25 August 2016

WILLOW TREE
PLANNING

**Submission to State Significant Development (SSD) 7424
Proposed Resource Recovery Facility, 52 Anderson Road, Smeaton Grange (Lot 319 in
DP1117230)**

drawing title  
ELEVATIONS 1

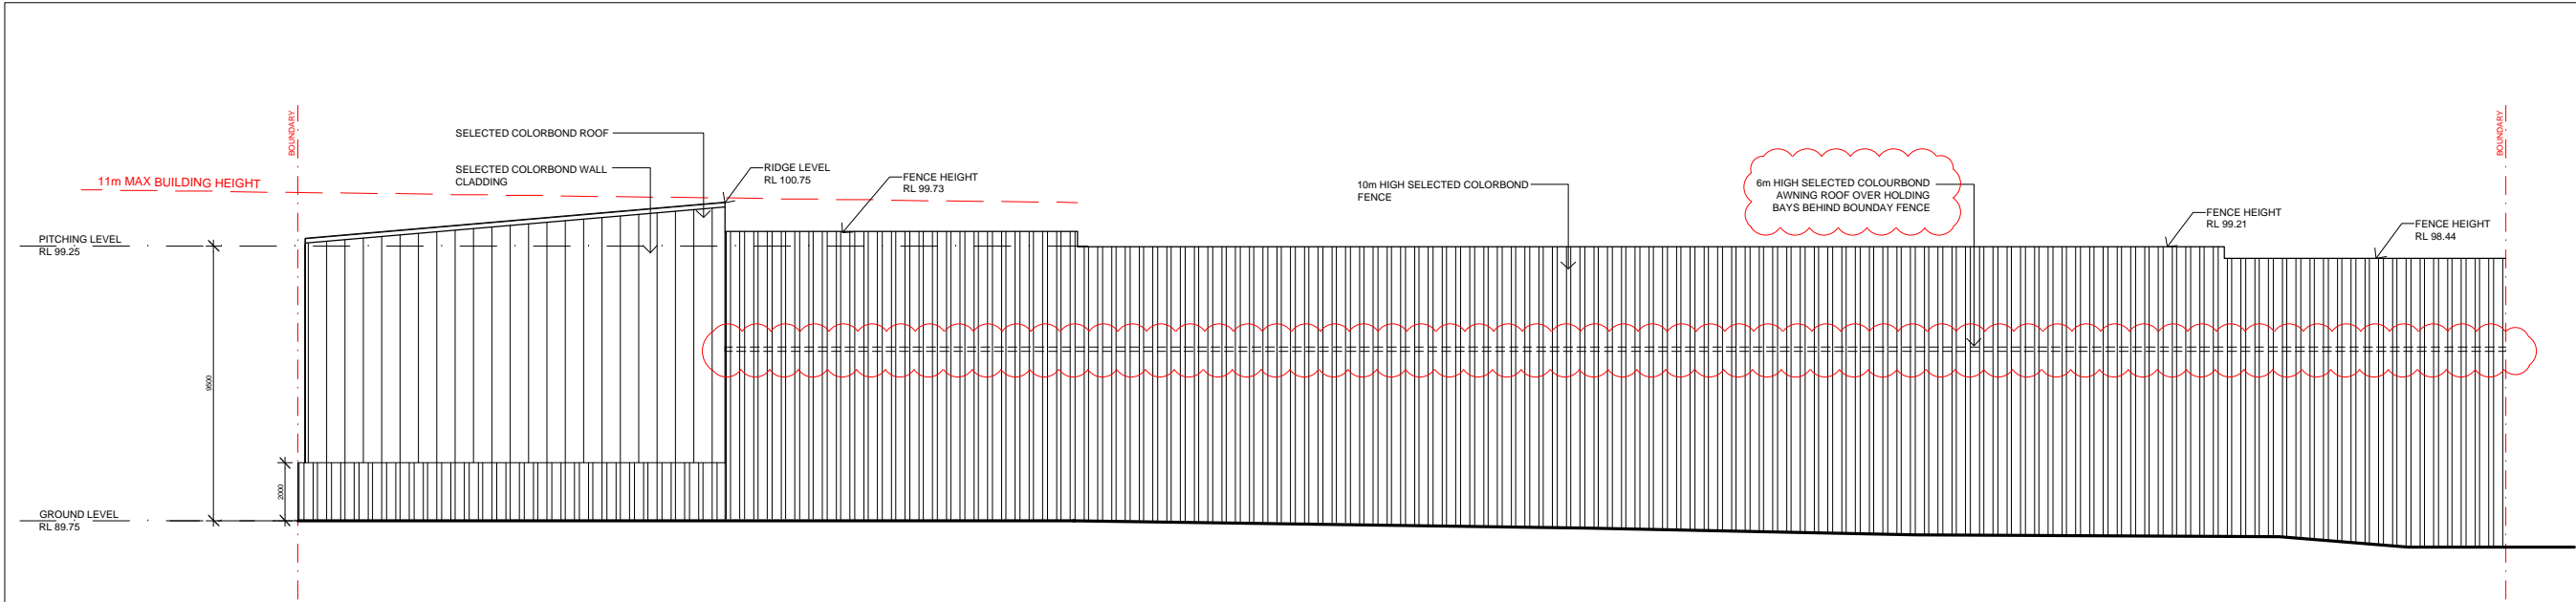
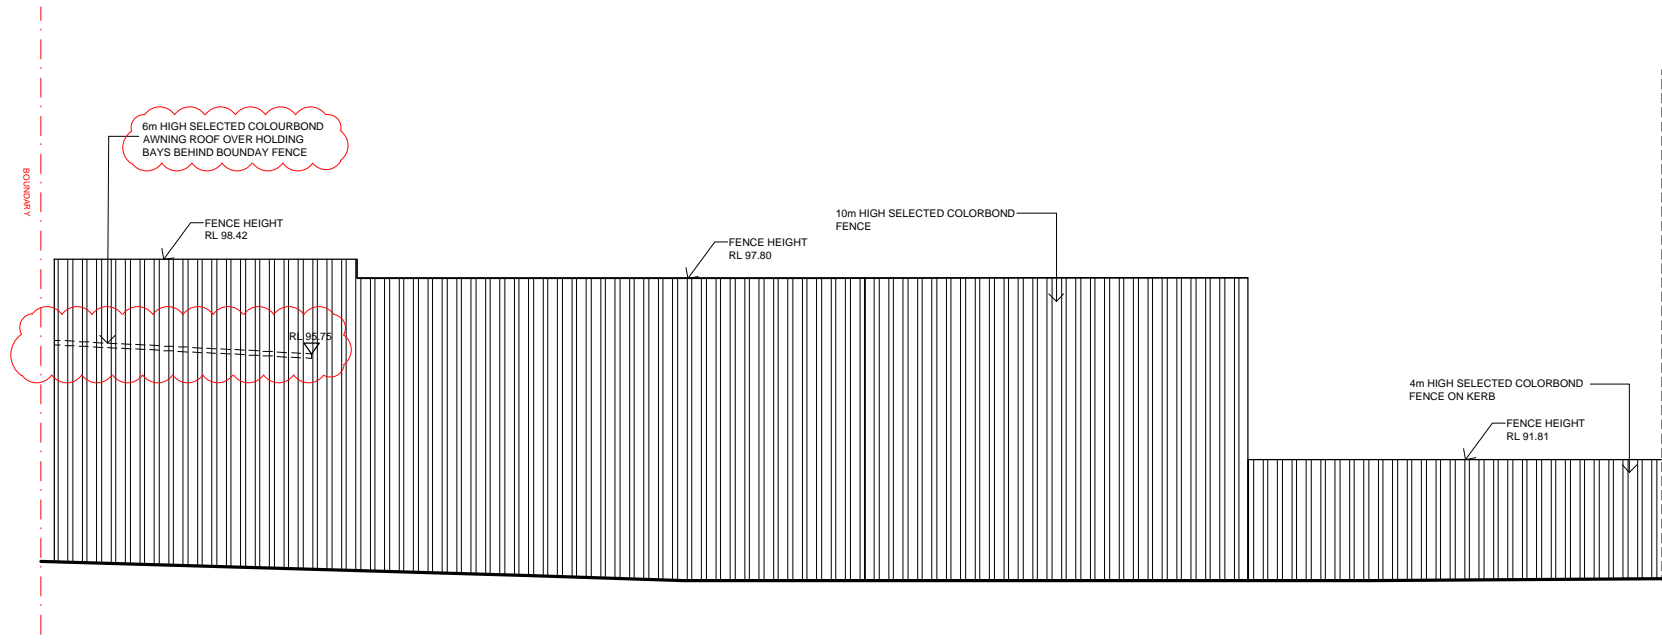
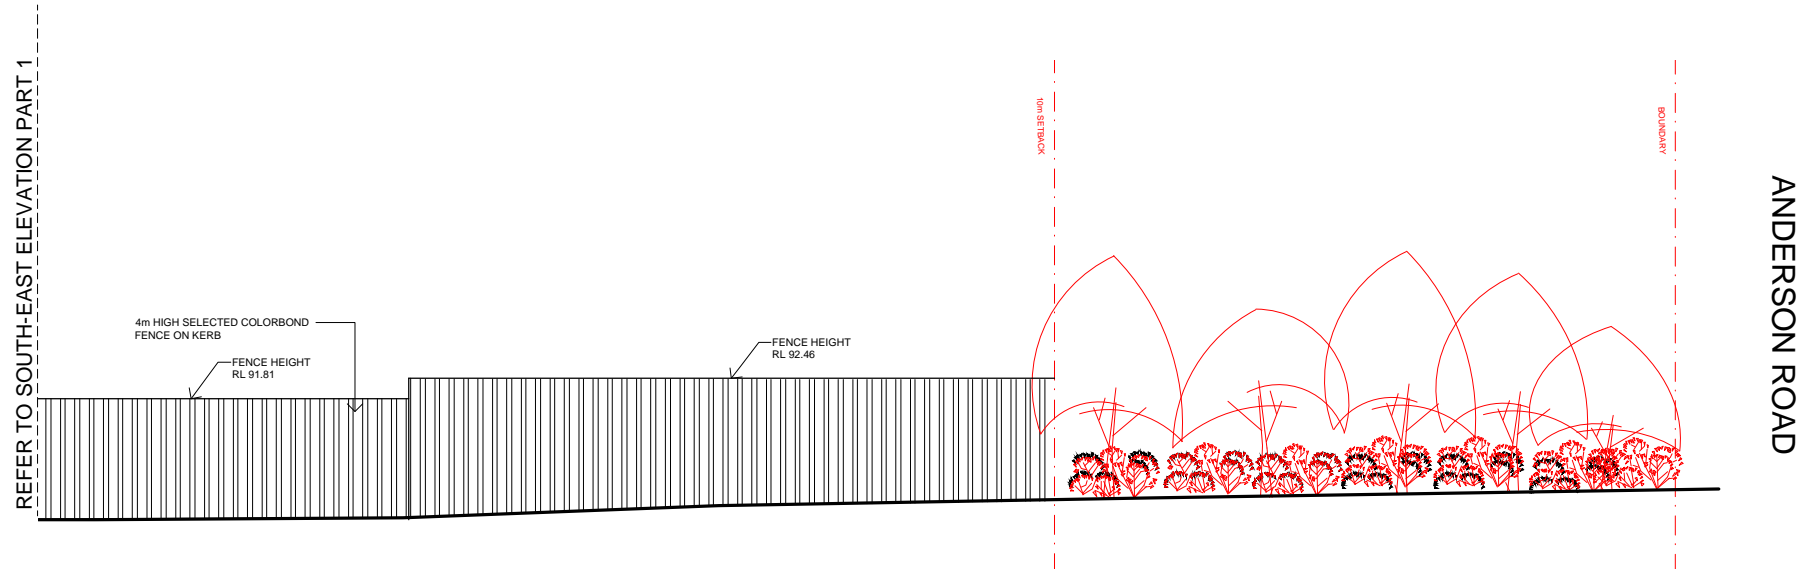
The site is subject to a 10m maximum building height limit as per the provisions of Camden LEP 2010. While Table 3.2 of the EIS acknowledges the proposal complies with this limit, no indication is provided of the actual height of the proposed development. It is requested that this detail is provided within the EIS so that the visual impacts can be fully understood.
